Application for a Non-Material Amendment Following a Grant of Planning Permission

Demolition of existing dwelling and garage and reconstruct new dwelling and double garage

22/02342/FUL

Proposed Floor Plans and Elevations drg no. SCKVR/PE/03

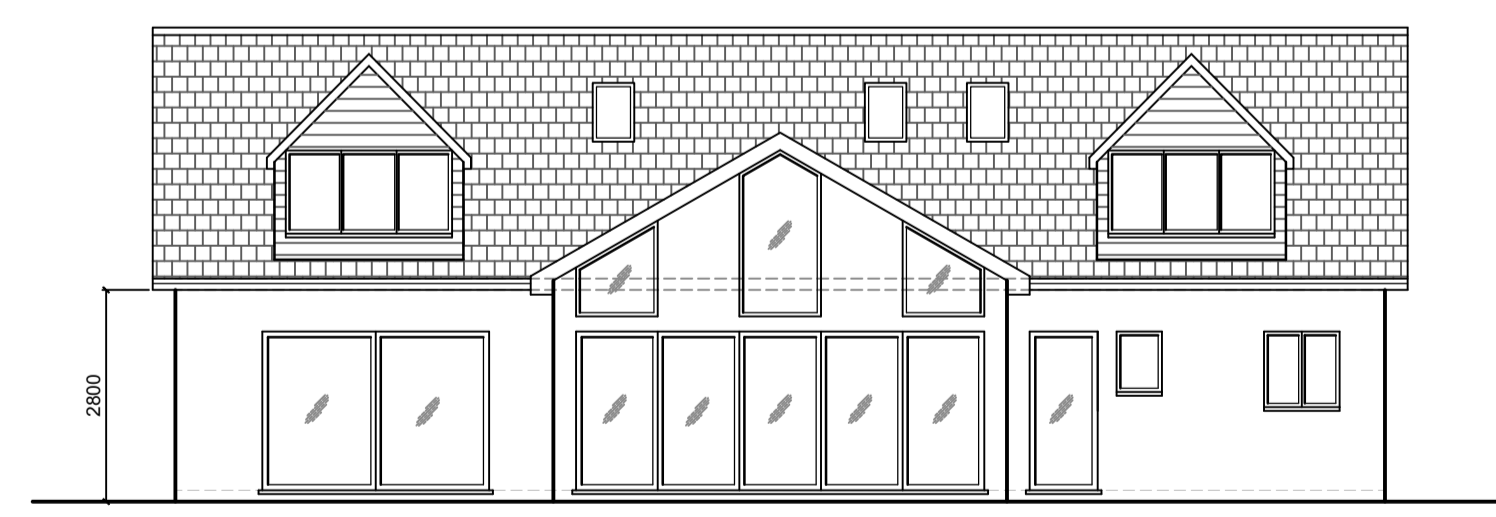
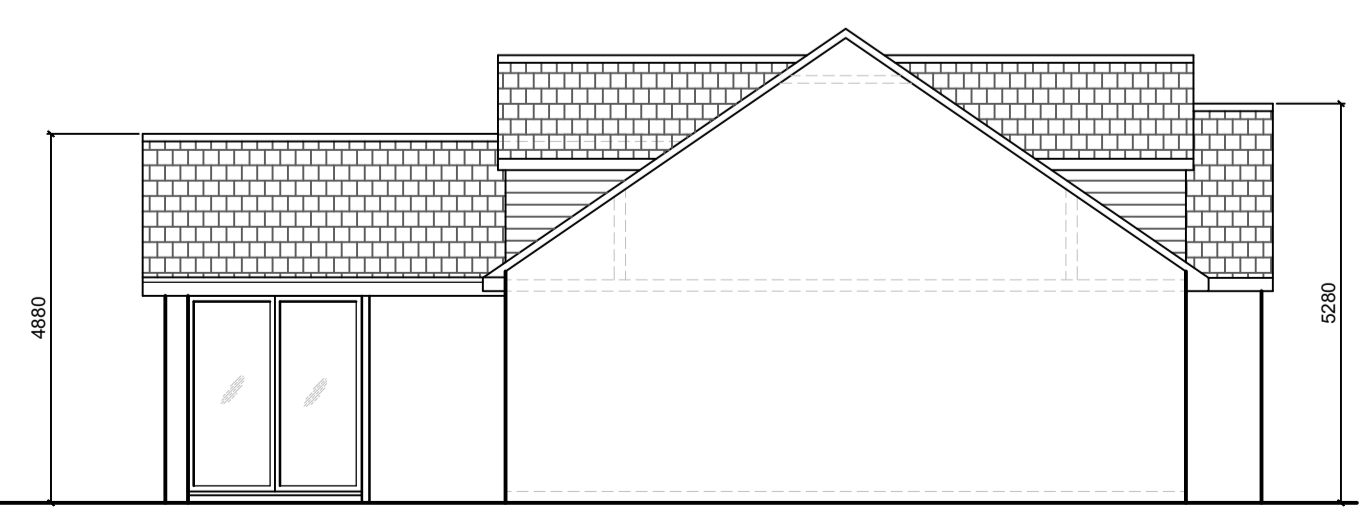
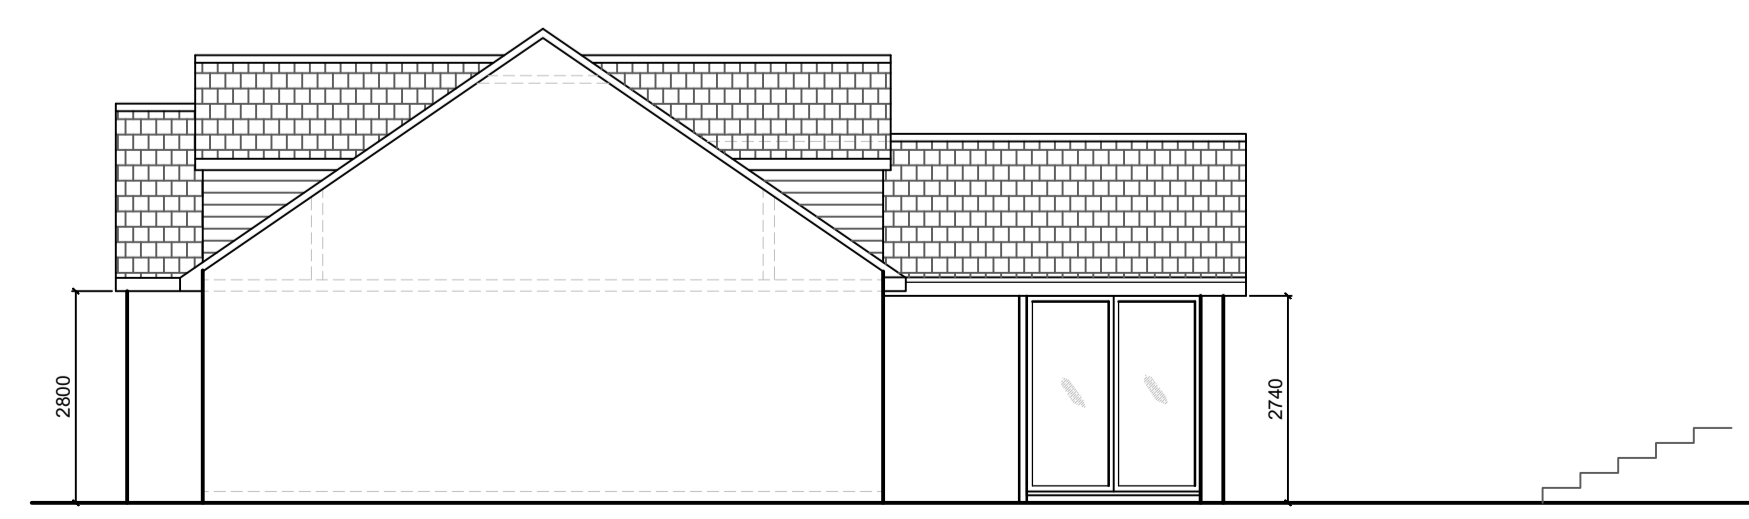
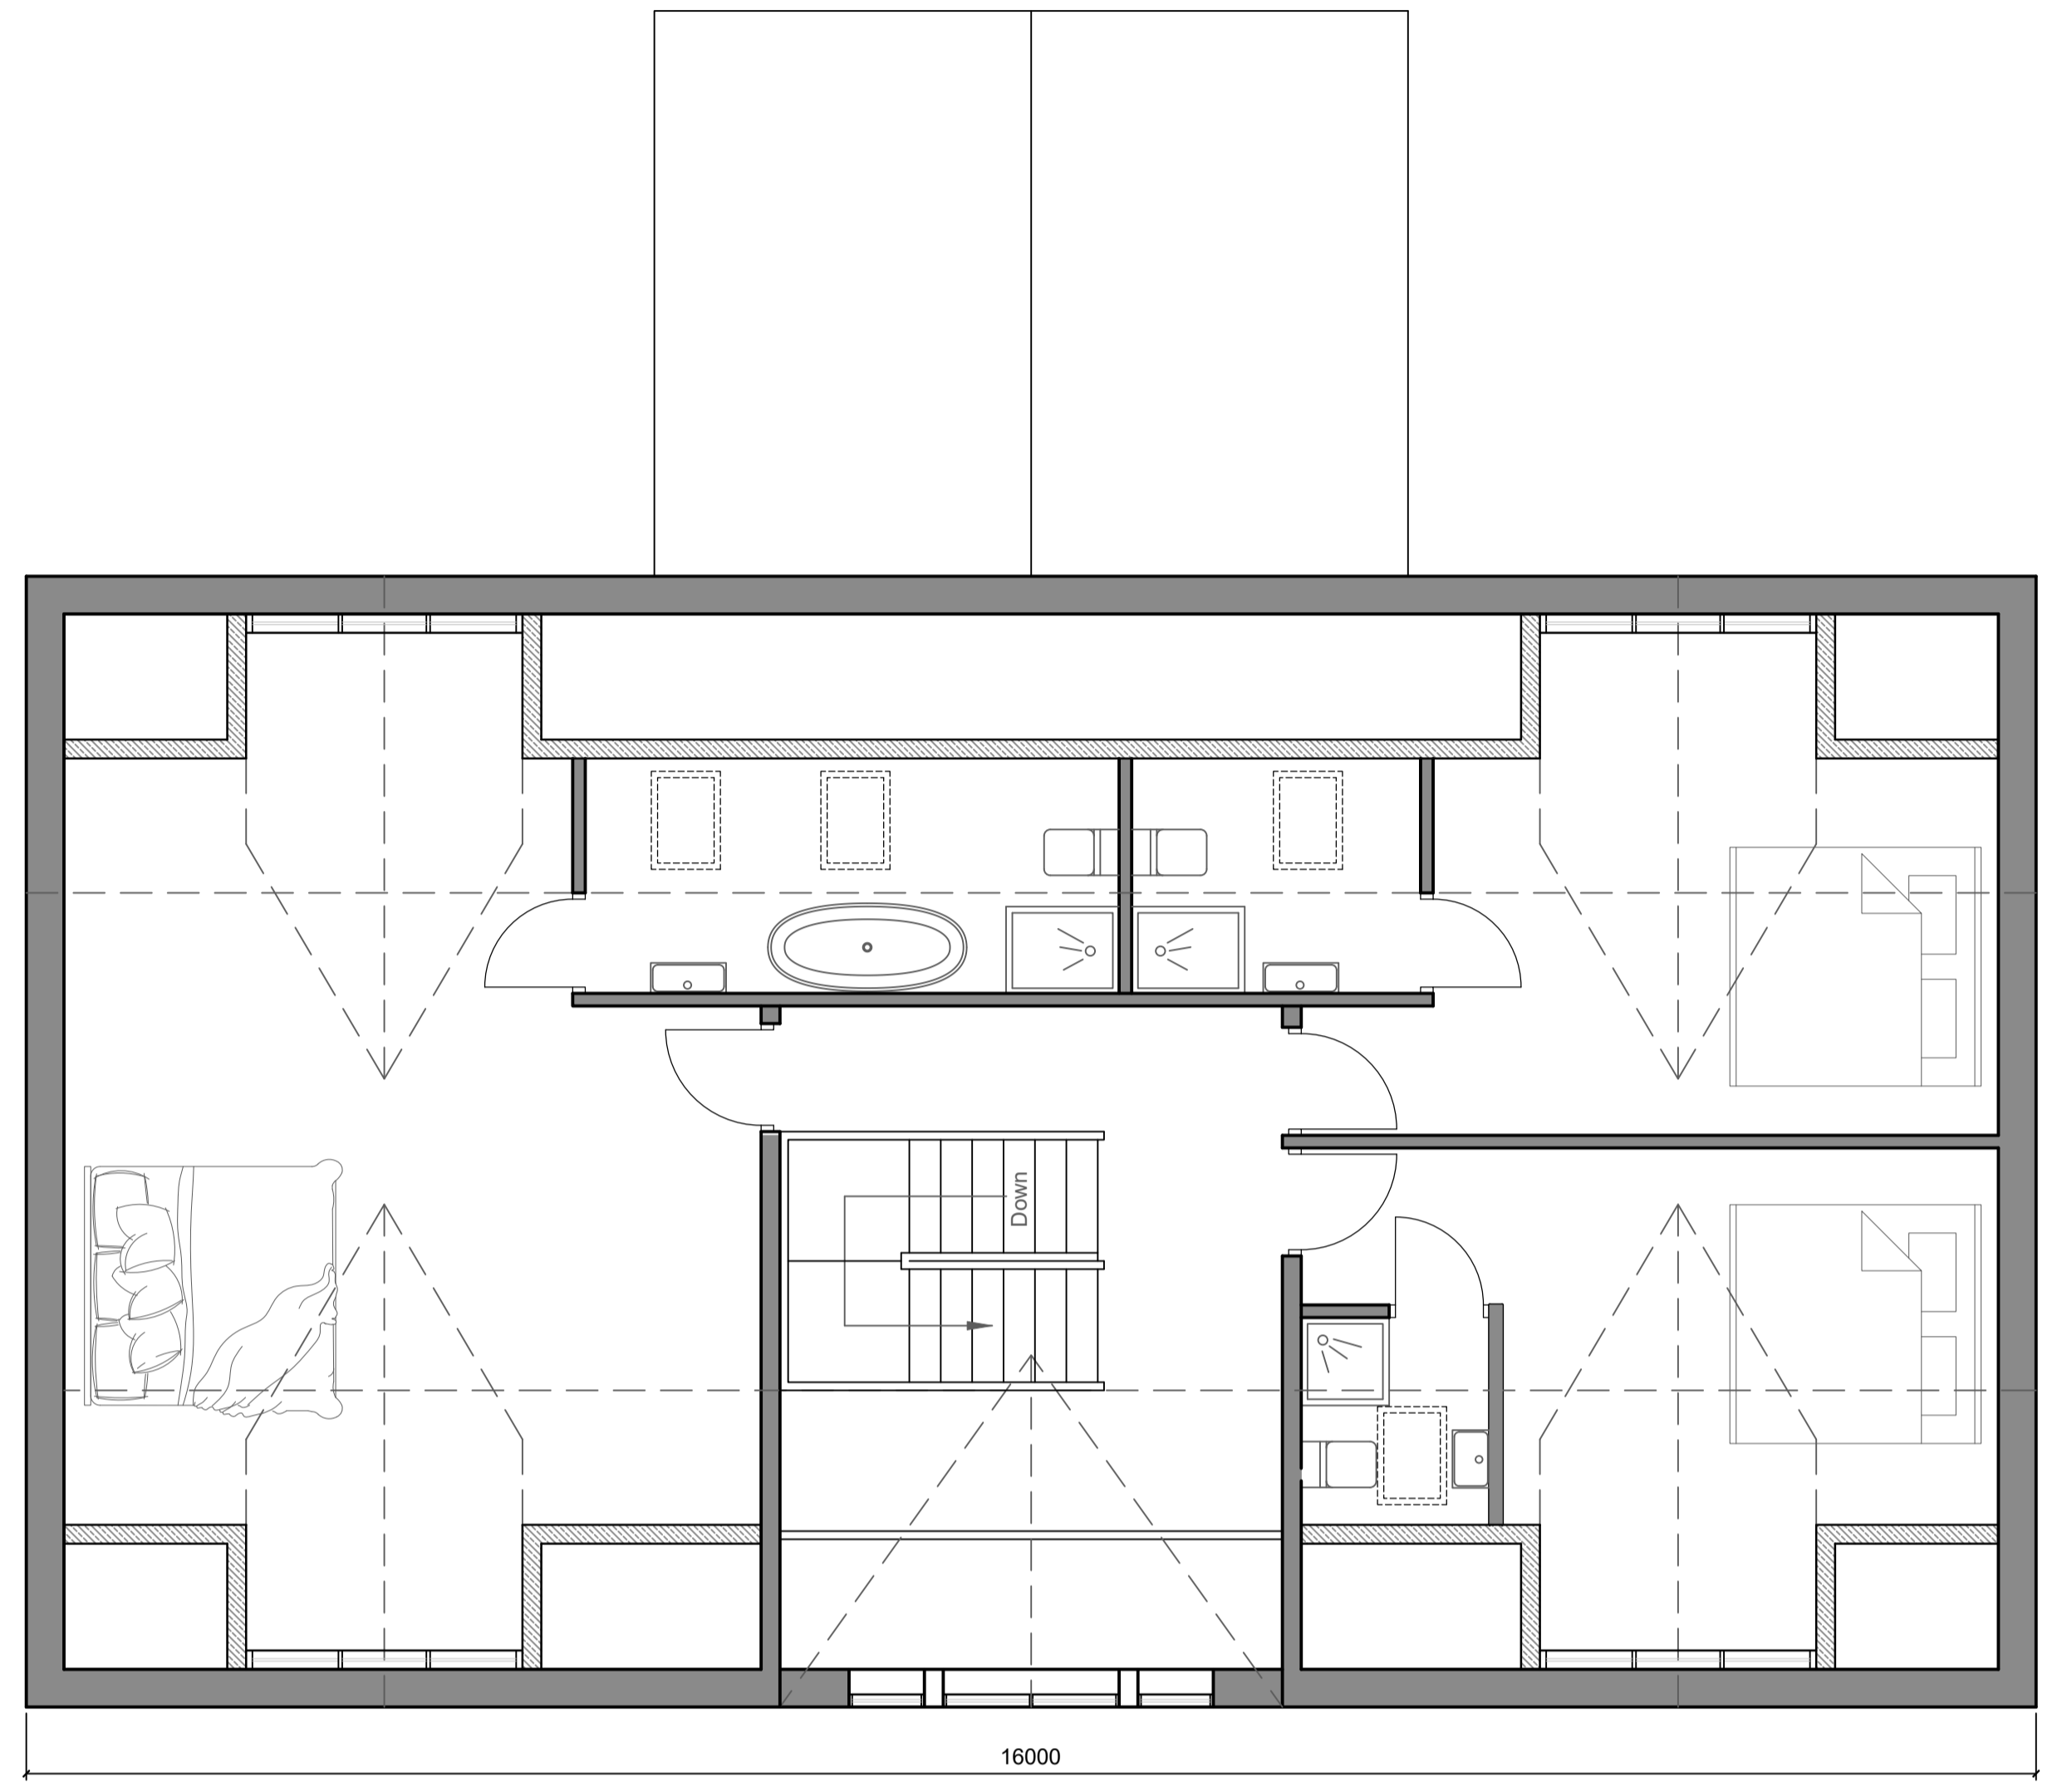
Replace skylights front and rear in habitable rooms with 2 roof dormer to the front and rear elevation

To provide proper egress windows and more natural light into habitable rooms.

Proposed Floor Plans and Elevations drg no. SCKVR/PE/003
